Our reference: ECM Ref: 9748526  
Contact: Kathryn Saunders  
Telephone: (02) 4732 8567

22 October 2021

**Response to Environmental Impact Statement: SSD-10272349, Proposed Yiribana Logistics Estate at 754-770 and 784-786 Mamre Road, Kemps Creek, Lot 60 in DP 259135 & Lot 59 in DP 259135**

E2 CORRIDOR ALIGNMENT PLAN
SCALE 1:500

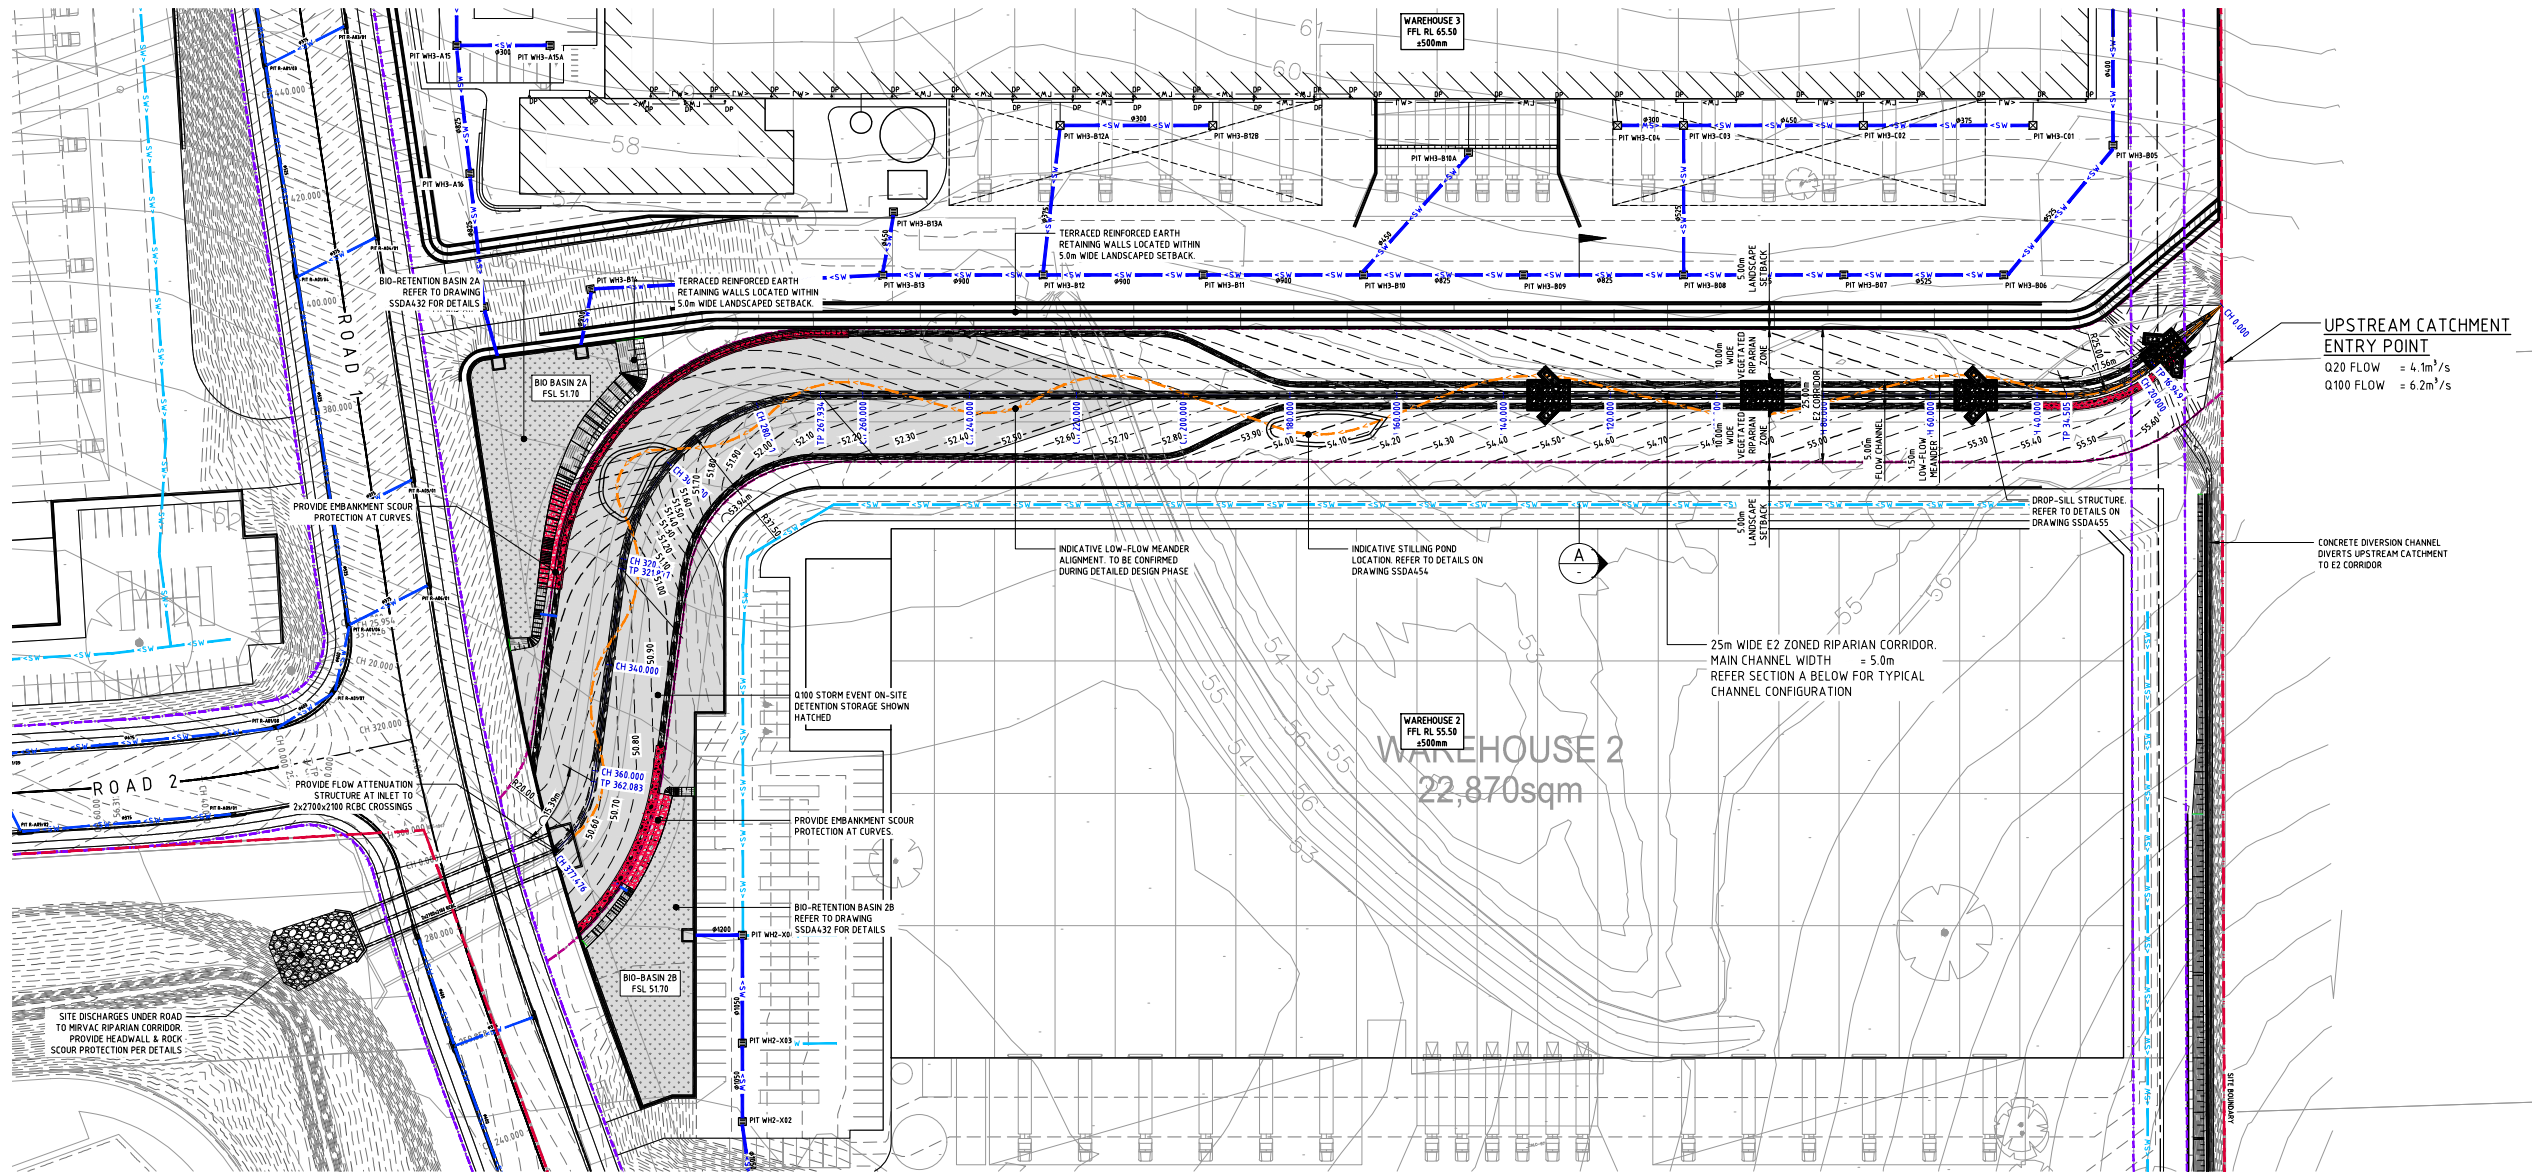
The proposal includes site clearing, extensive cut and fill works and civil works to remove an identified riparian corridor and to construct a warehouse and ancillary structures over this land which is located within an E2 Environment Conservation zone under SEPP WSEA.

The proposed works are not permissible within the E2 zoning and are in stark opposition to objectives of the E2 Environment Conservation zone.

The proposed 5m wide battered setback to the Top of Wall of the drainage channel is insufficient to sustain large trees, this shall be widened significantly to allow roots to grow which will not compromise the integrity of the channel's retaining walls and so as not to overhand or otherwise negatively impact on the warehouse hardstands and ring roads. As proposed tree canopy will overhand and may require that tree be eventually removed or at the least will be significantly lopped.

Steps in landscaped retaining walls should be widened to better address height differences and scale. Should DPIE support the channel, vertical retaining walls within the drainage channel are not supported, these are to be sloped/battered to allow for a more nature appearance and to enable land based fauna to escape the channel and to move between tiers.

LONGITUDINAL SECTION - GPT E2 CHANNEL

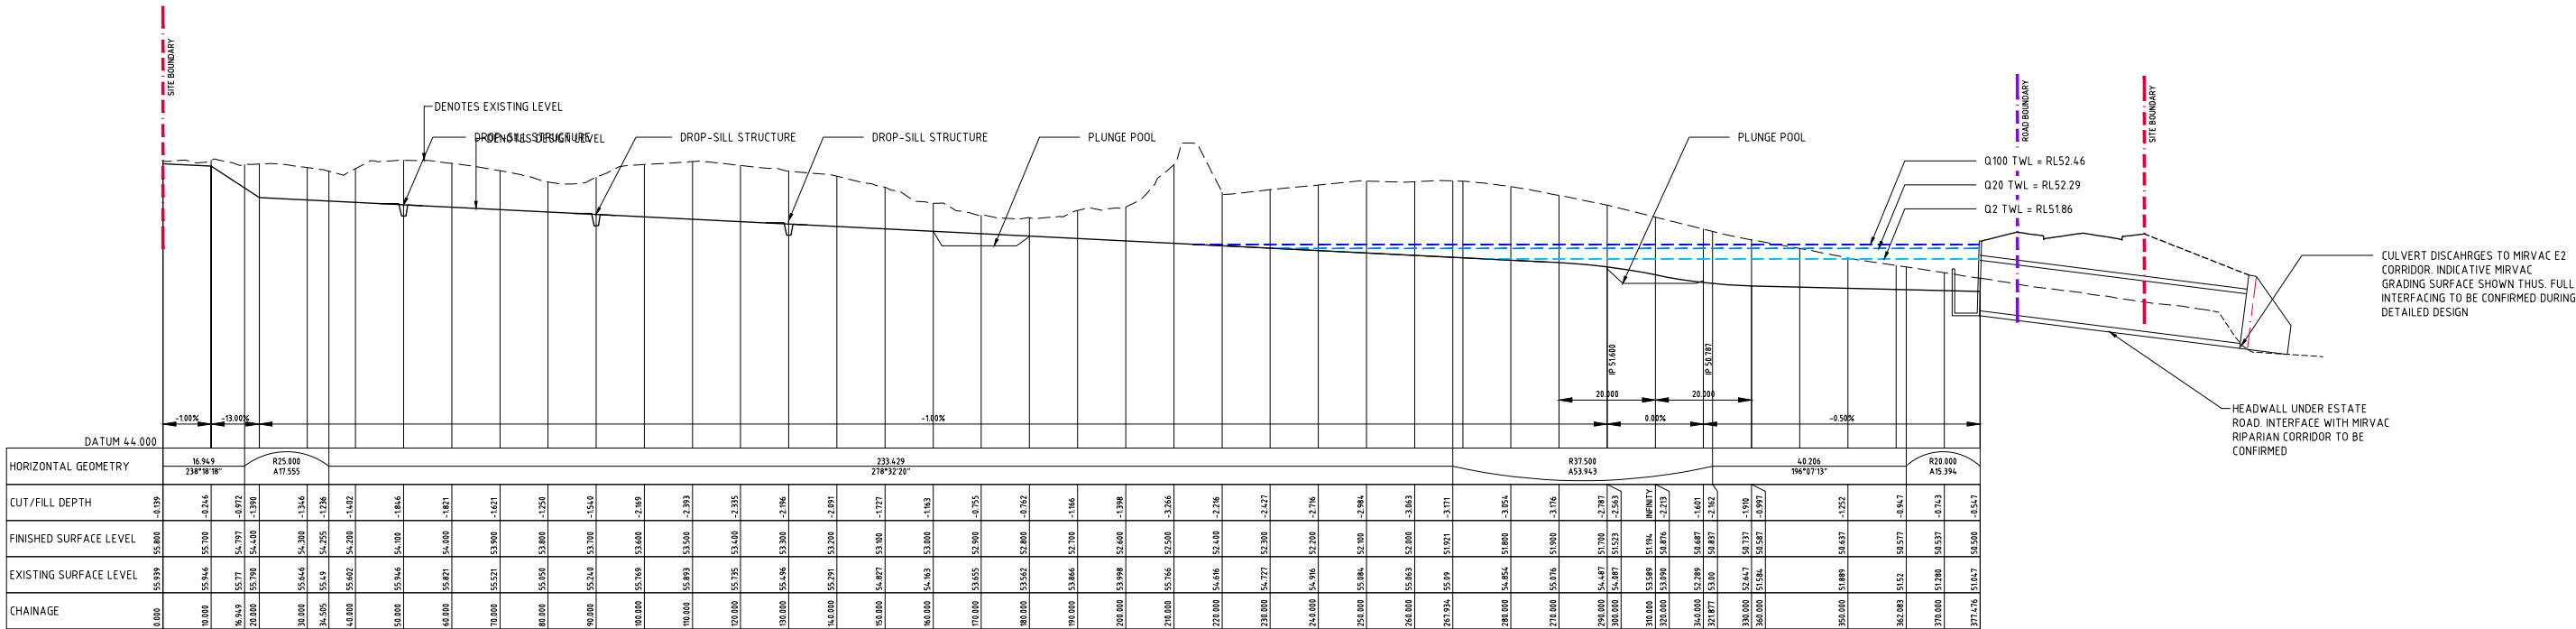
In addition, the design and proposed landscaping shall be reviewed by a specialist ecologist with the aim of including in its design (including safety fencing and retaining walls), measures to assist land-based fauna to enter and exit the channel without becoming trapped and with the aim to assist and promote fauna to move along the corridor freely.

ROADWORKS MASTER PLAN
SCALE 1:1000

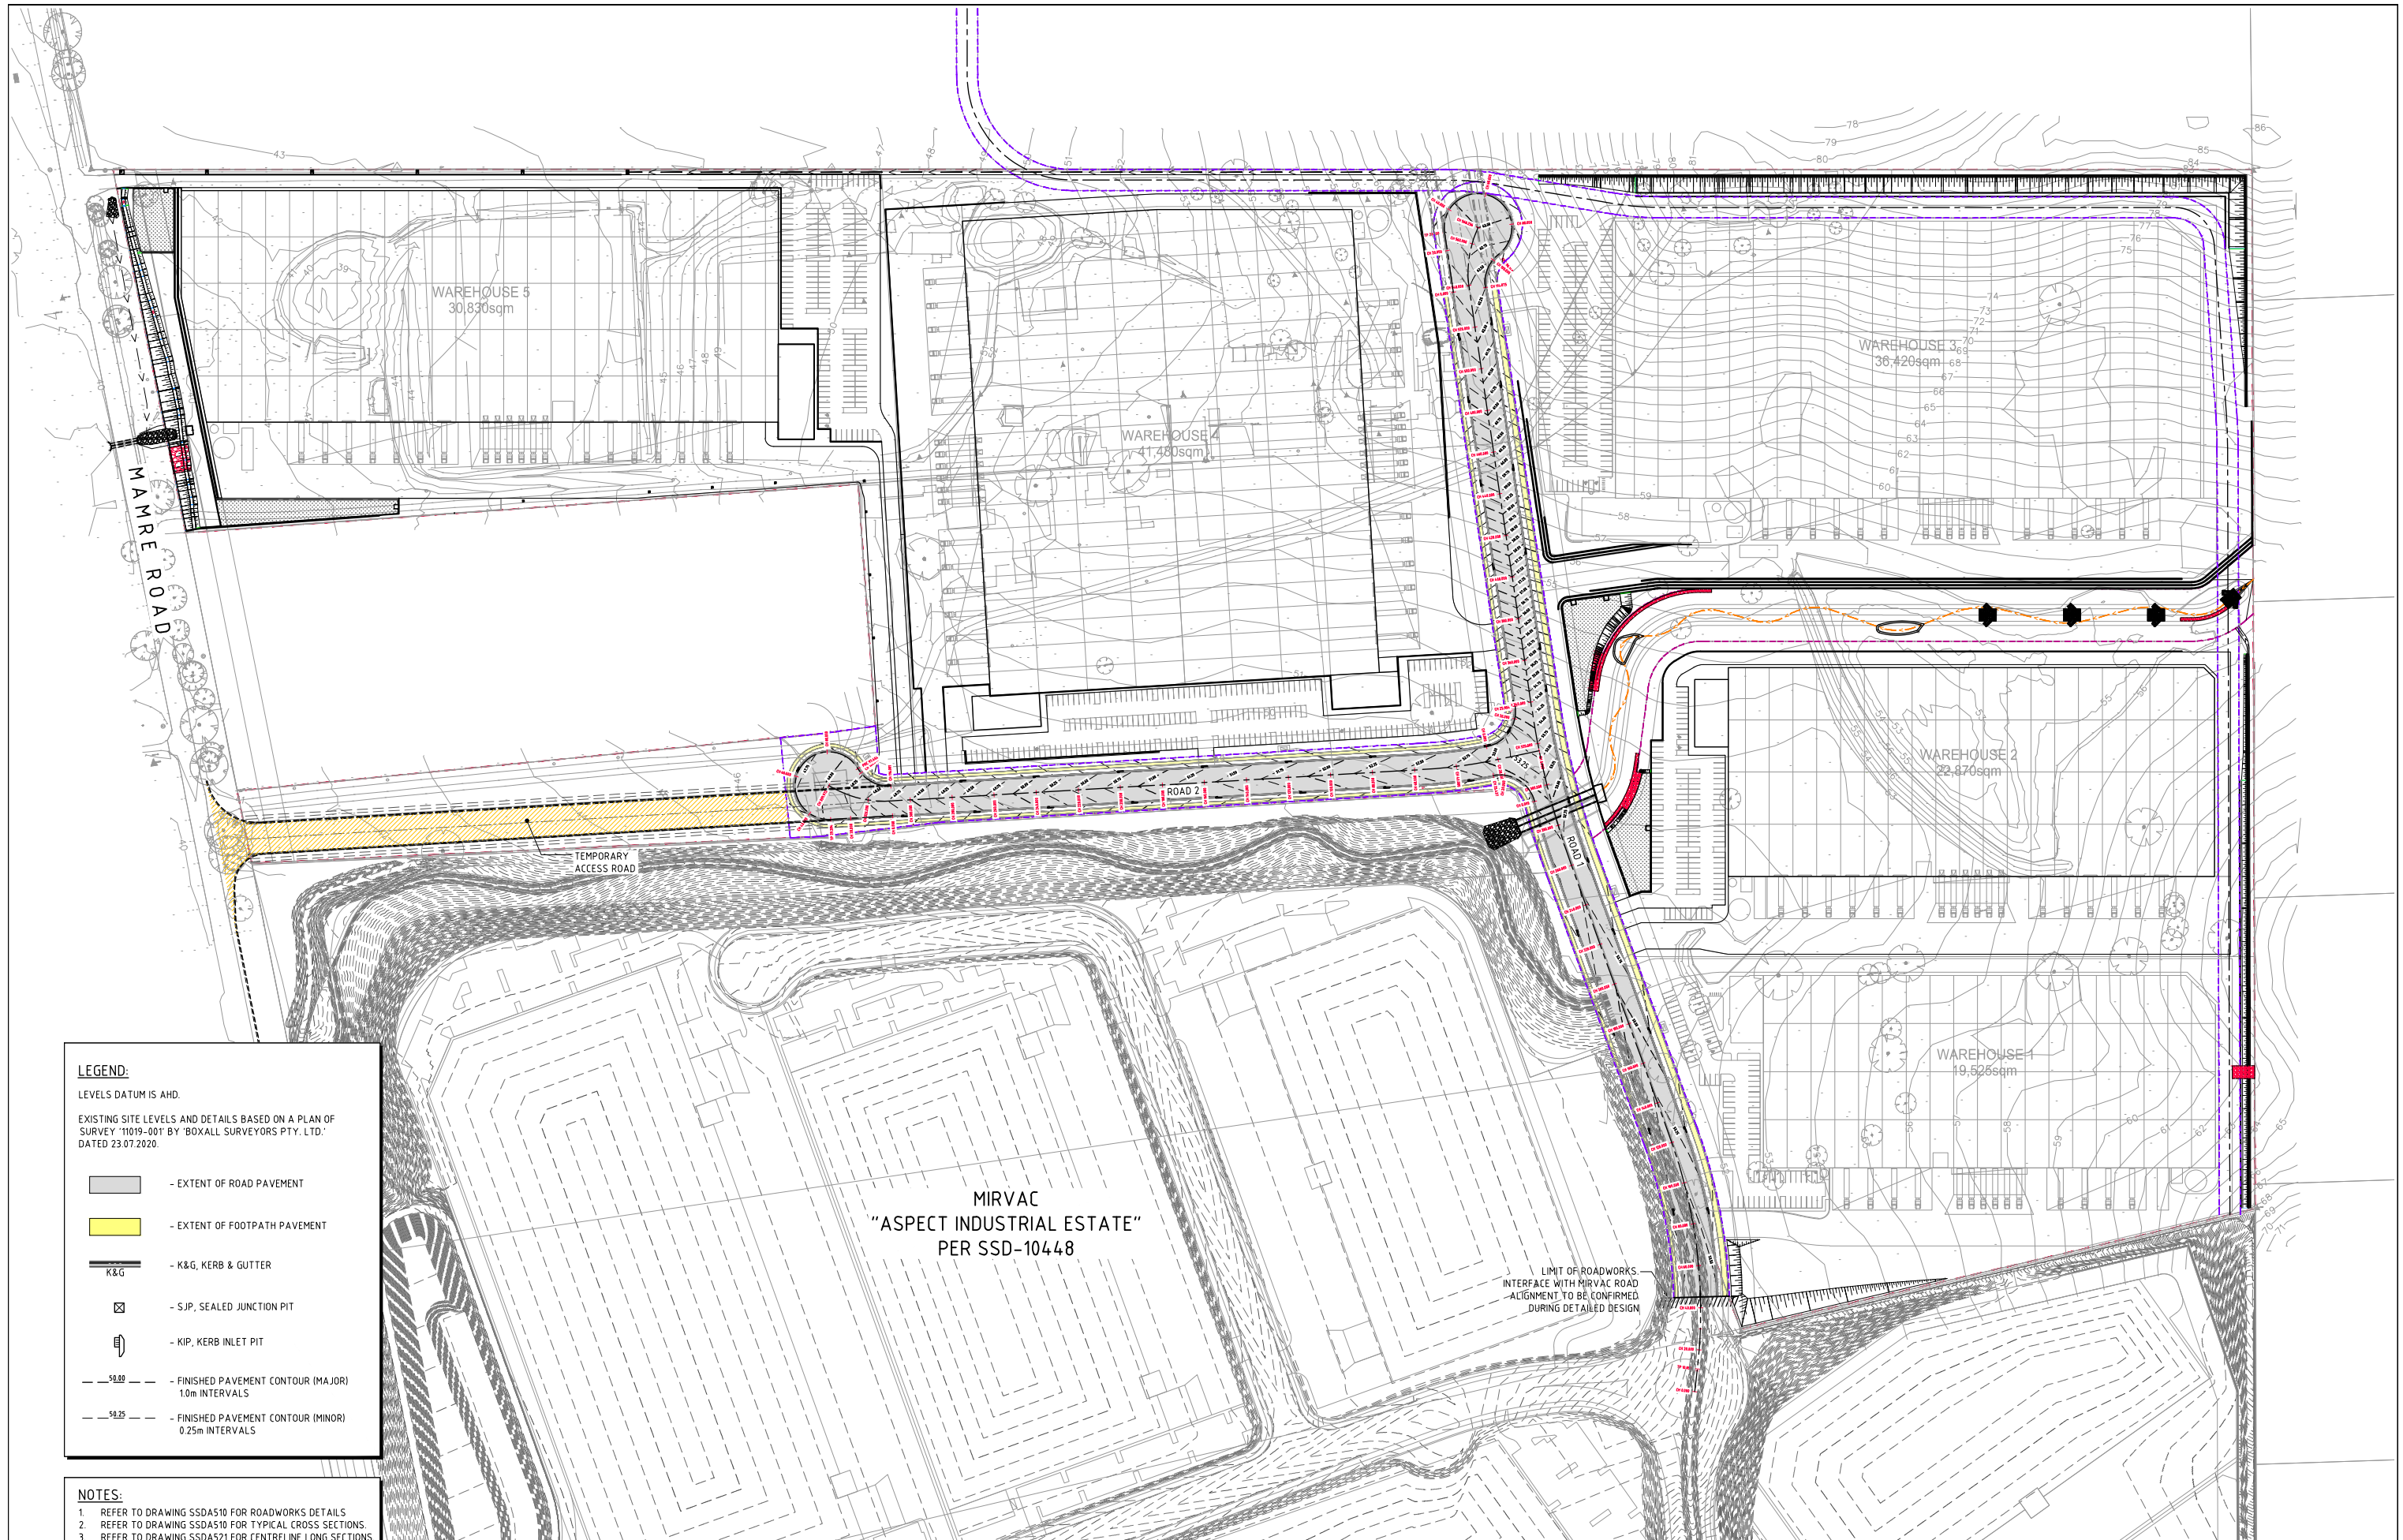
Council does not agree that the proposed most southern east-west roadway can be defined as a 'Local Industrial Road'.

This proposed future road should be classified as a Distributor/Collector road (Type 2), having regard to the DCP road typologies at Table 9, and as such, its design shall align with the arrangement of roadway infrastructure identified in Figure 13 of the DCP, and shall have a minimum roadway width of 26.4m (variable to 30.6m at intersections). This roadway proposes a future intersection with Mamre Road (see **Image 5**).

The proposed clustering of vehicle entry and exit points in the south-western cul-de-sac is not supported by Council owing to the future entry/exit requirement for the adjacent lots, the classification of the east-west road as a Distributor/Collector Road (typology, Type 2 under the DCP) and the insufficient design standards and also noting the need for a future intersection with Mamre Road, and for safety and traffic engineering reasons. Clustering of signage (p.51 of EIS) is also proposed in this location.
